CITY OF ALBUQUERQUE

April 14, 2023

Re: Raising Cane's #705
2004 Wyoming Blvd. NE
30-Day Temporary Certificate of Occupancy
Transportation Development Final Inspection
Engineer's Stamp dated 06-21-22 (H20-D003D)
Certification dated 04-05-23

Drawing file: TCL DATE SUBMITTED 4-5-23 / C5.0(R) - SITE KEYNOTE PLAN.pdf

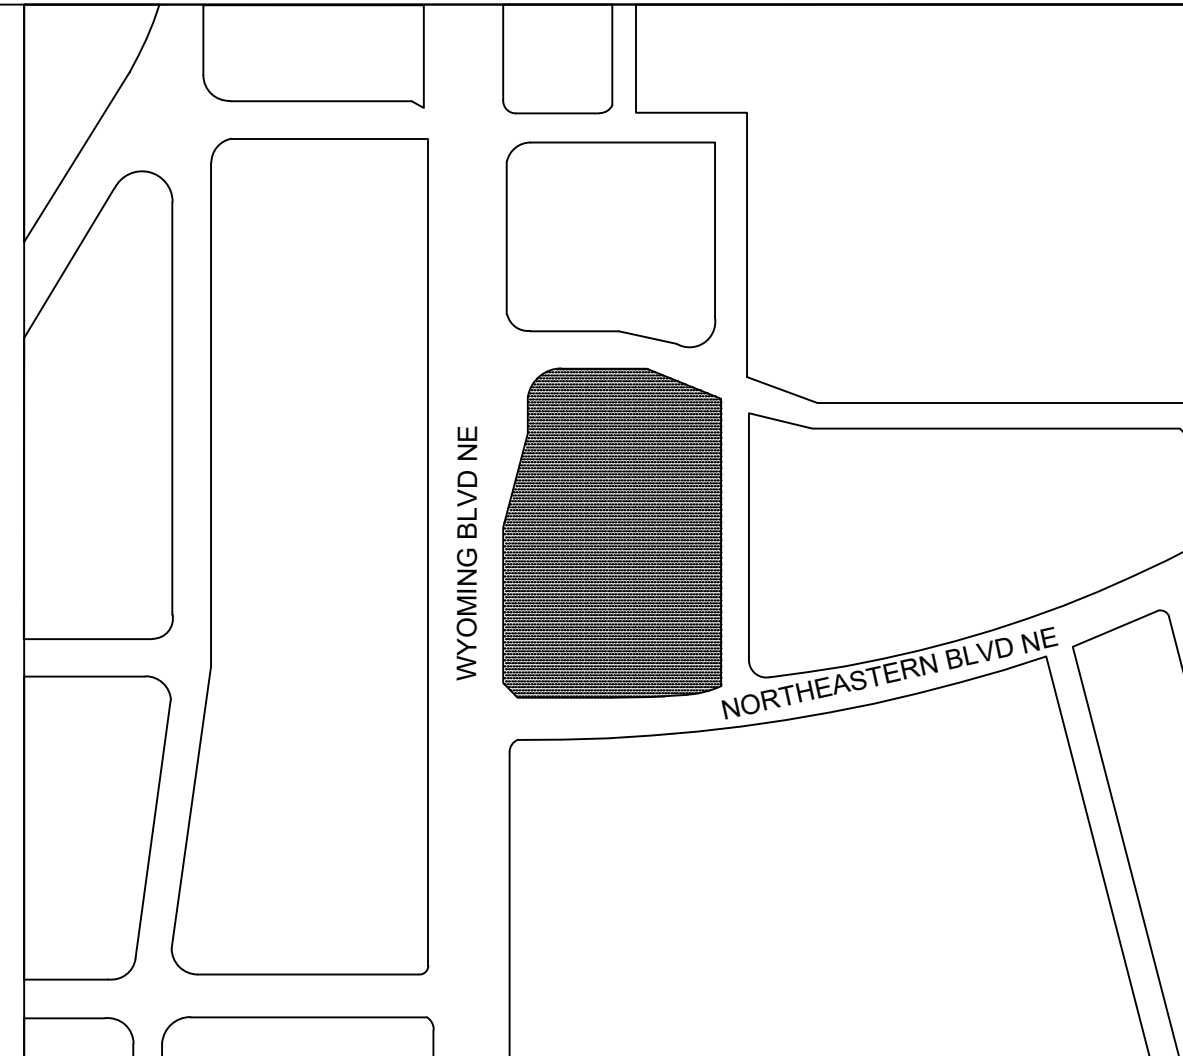
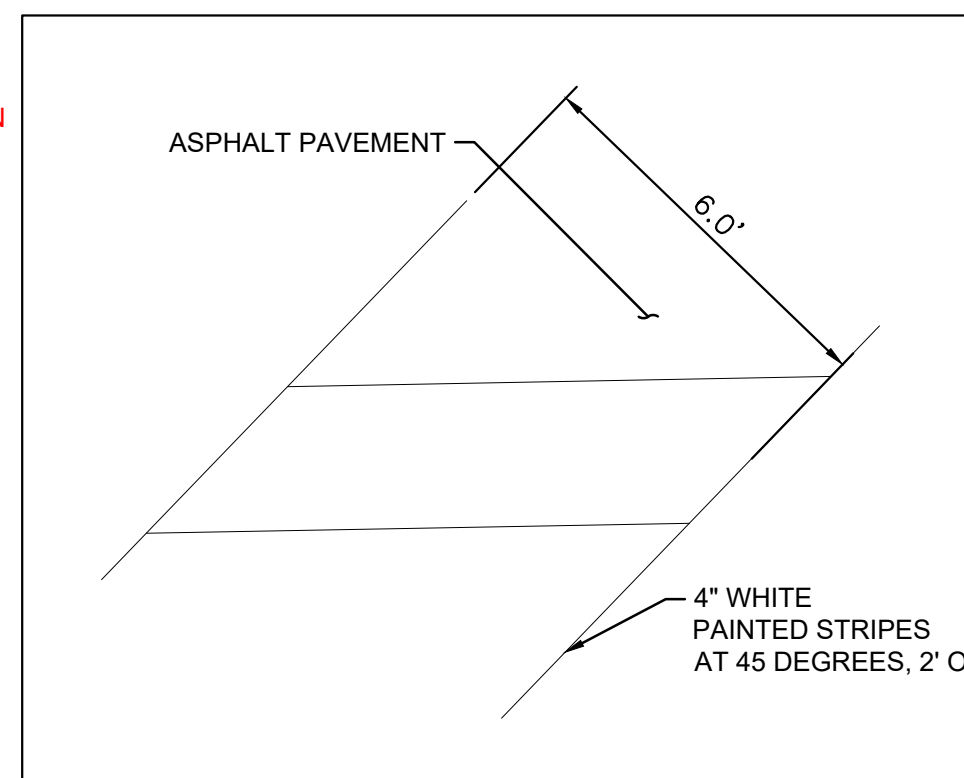
- Key note G: Per approved site plan, please install Truncated Domes on all wheelchair ramps.
- Please finish the pathway stripes at the south west side of the site.
- Please remove one of the "Do Not Enter" signs because it is confusing for vehicles entering the site off Wyoming. Remove the sign that located at the west side of the drive-thru exit.
- Key note z: please complete the asphalt pavement.
- Per site visit: the length for the ADA parking space at the east side of the MC parking space is 15'. Please provide a minimum 18' long ADA parking space.

Once these corrections are complete, email pictures to malnajira@cabq.gov for release of Final CO.
